DEVELOPMENT REVIEW BOARD
SUPPLEMENTAL SUBMITTAL

PROJECT NO. PR-2018-001405
Application No. SD-2022-00100

Re: Final Plat Review for Proposed Subdivision of Tract B, Nuevo Atrisco

**Plat for
 Tracts B-1, B-2, and B-3
 Nuevo Atrisco
 Being Comprised of
 Tract B
 Nuevo Atrisco
 City of Albuquerque
 Bernalillo County, New Mexico
 June 2022**

**Plat for
Tracts B-1, B-2, and B-3
Nuevo Atrisco
Being Comprised of
Tract B
Nuevo Atrisco
City of Albuquerque
Bernalillo County, New Mexico
June 2022**

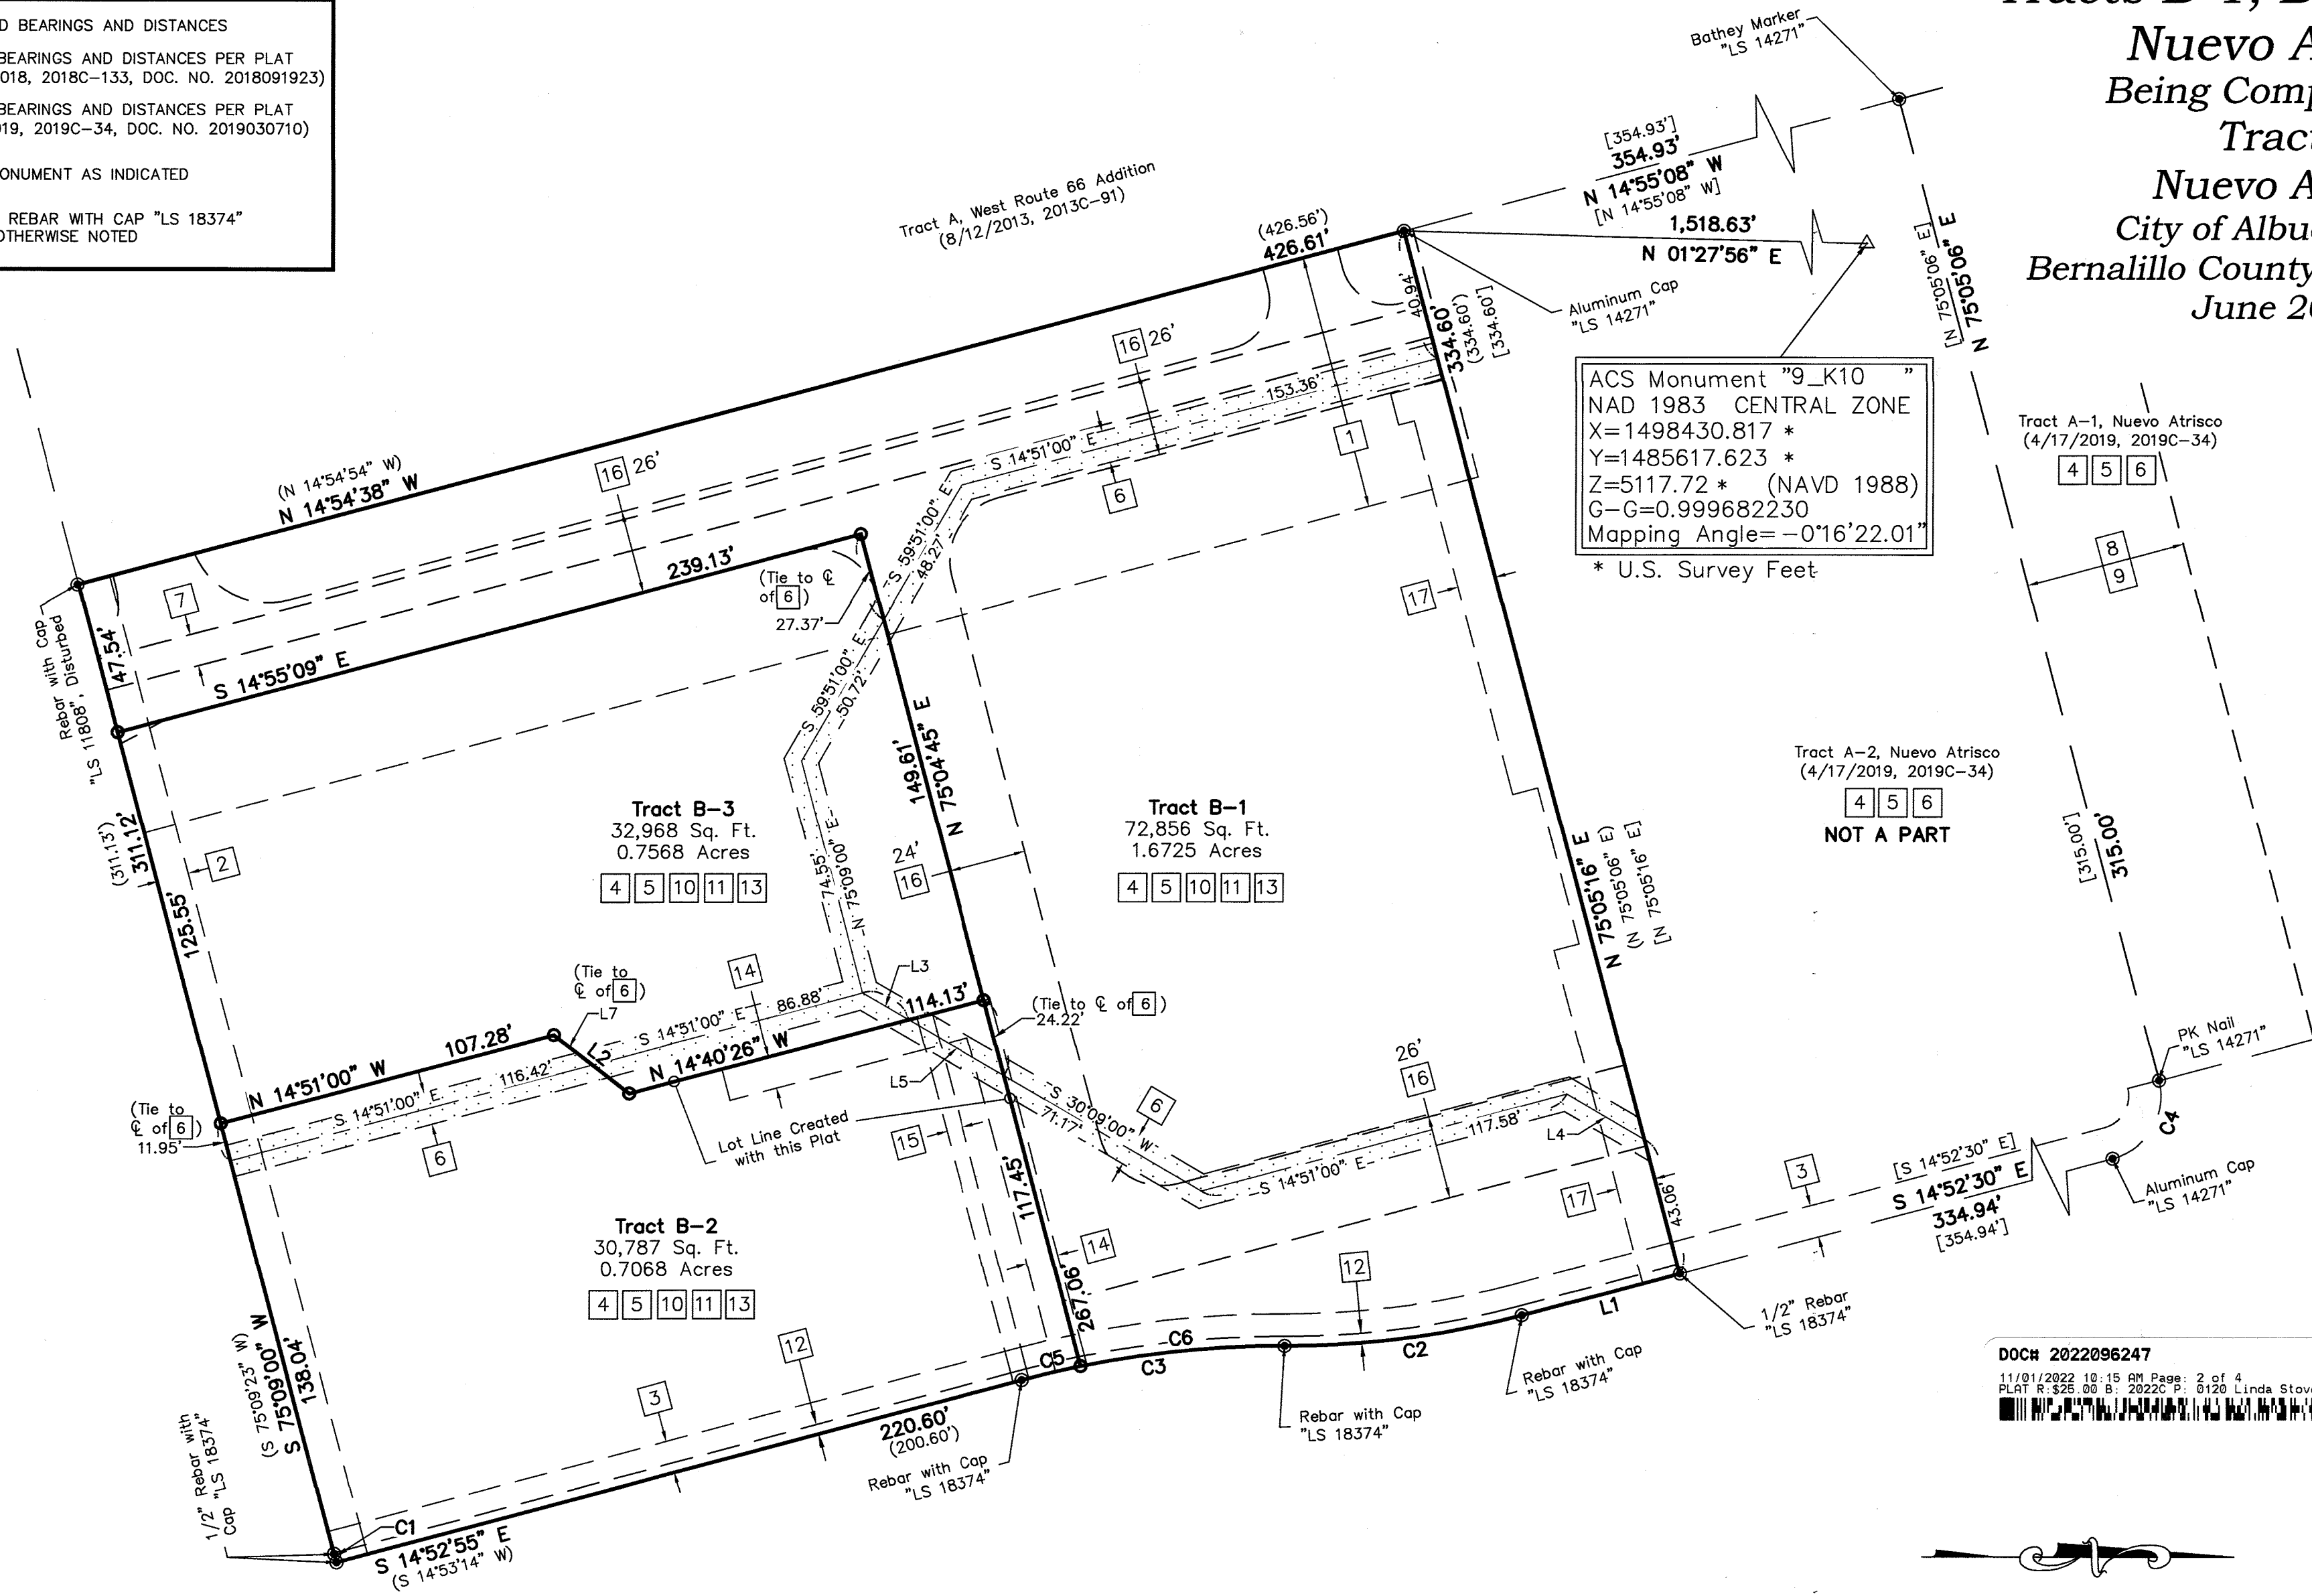
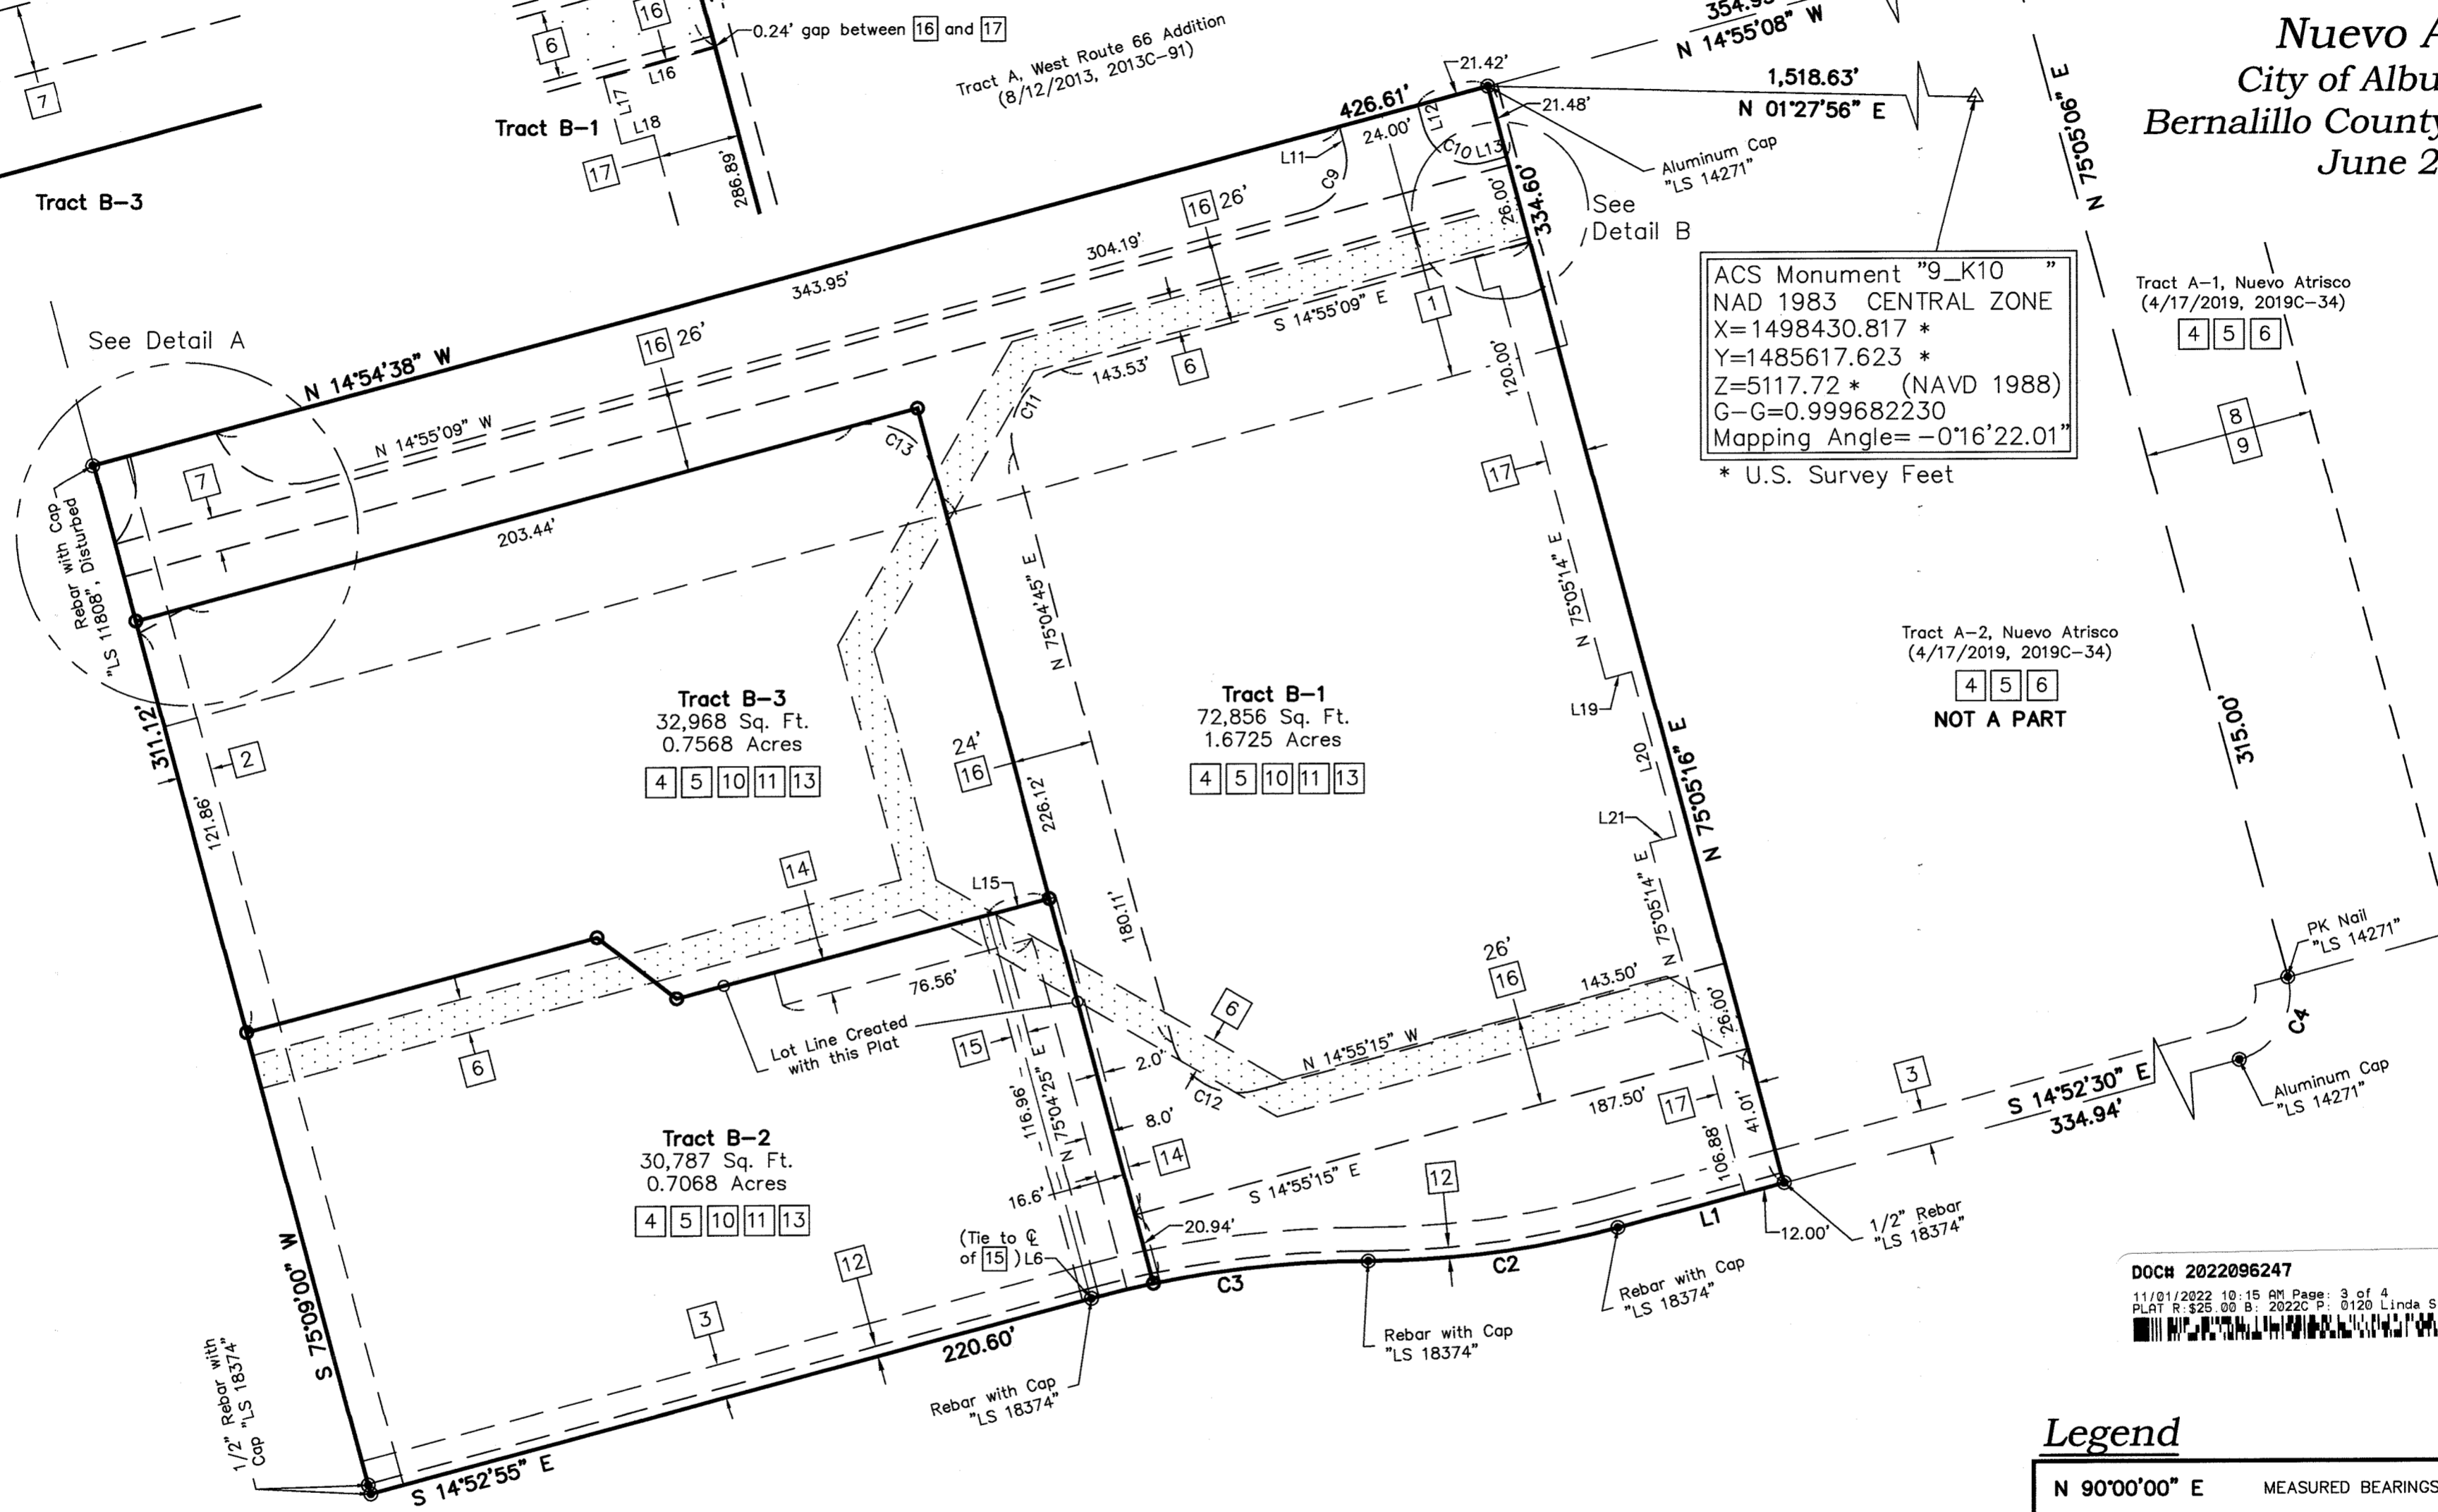
- The application number must be added to the Plat.
- DXF file approval email from AGIS must be submitted prior to final sign-off from Planning.
- All standards within IDO section 5-4-C (Subdivision of Land Compliance) apply to all replatting actions. Re-plating action cannot increase any existing nonconformity or create a new nonconformity.

Noted, application number has been added to the plat. DXF approval dated June 27, 2022 is also attached with this supplement.

LANDSCAPE PLAN

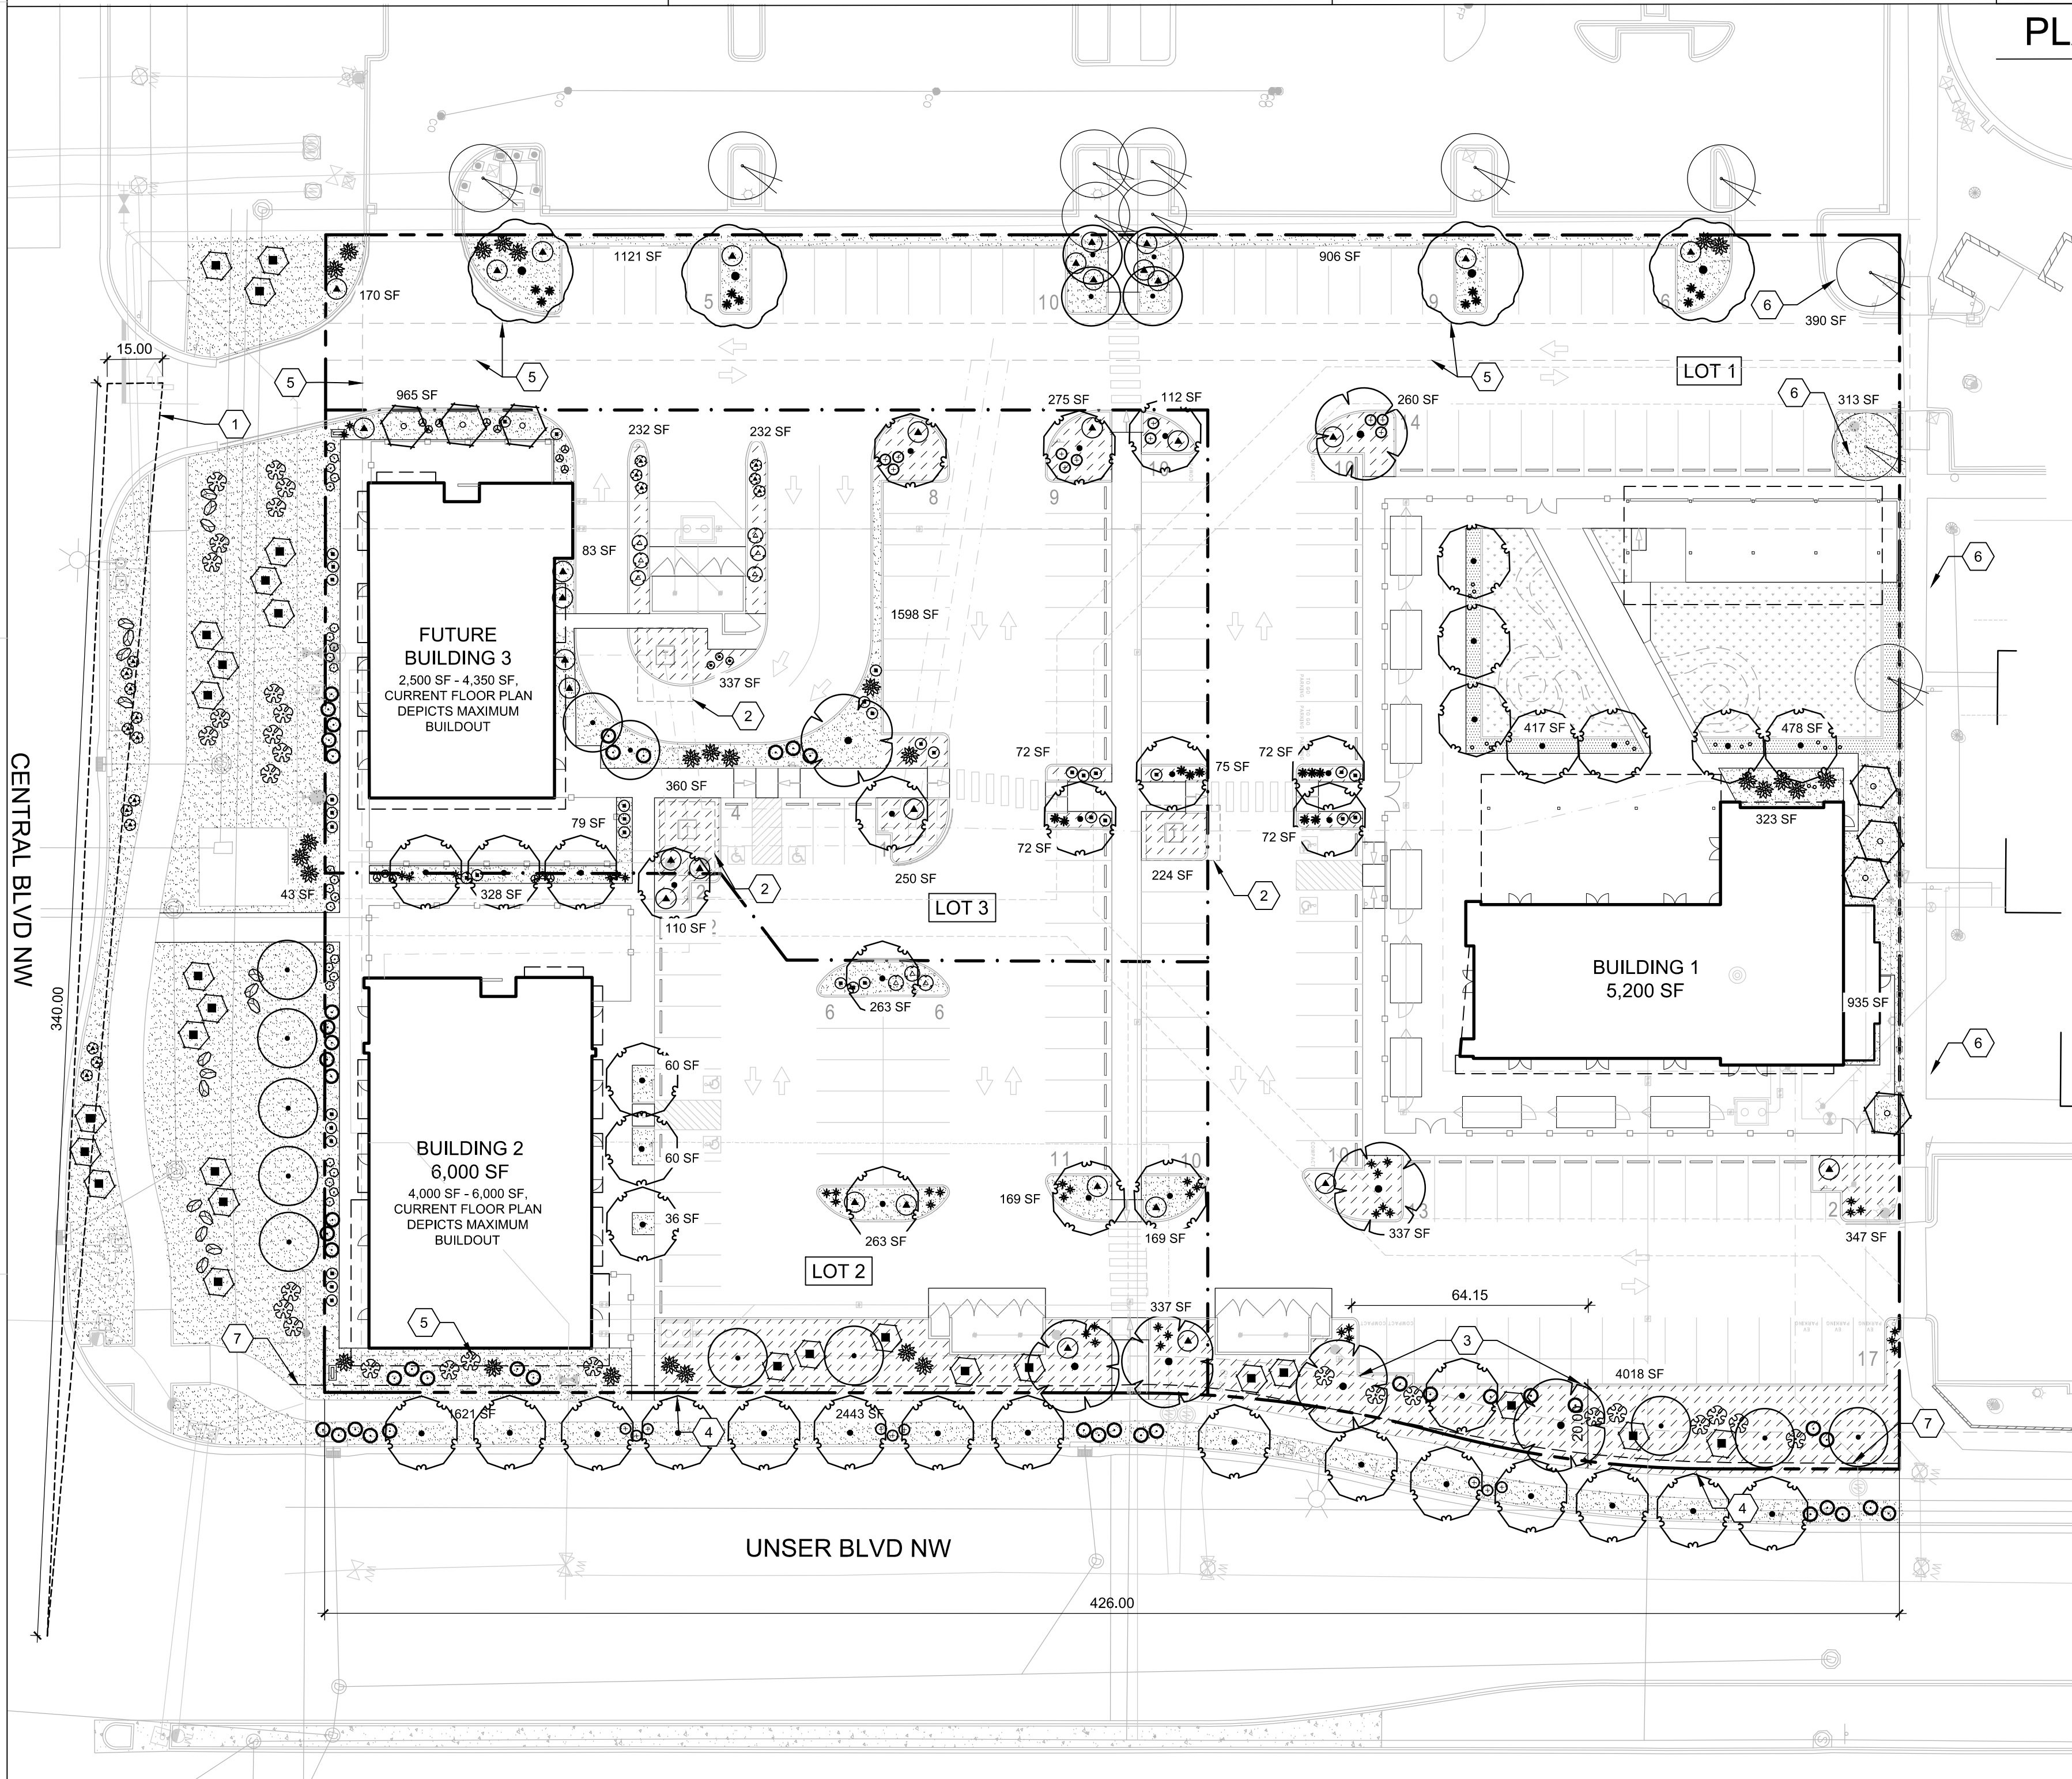
1. It is unclear when the City project will be complete and the number of street trees planned? Street trees are typically required by the applicant in the landscape buffer inside the property line. Is it possible to provide more trees?

2. The Urbanite Ash is not a recommended tree on the City's Official Plant Palette due to drought and heat stress. The Nature Conservancy's NM Climate Ready List may show additional options for the parking lot.

Per engineer discussion during site plan hearing, landscape buffer is very crowded with various utility lines. See site plan application for further landscaping discussion.
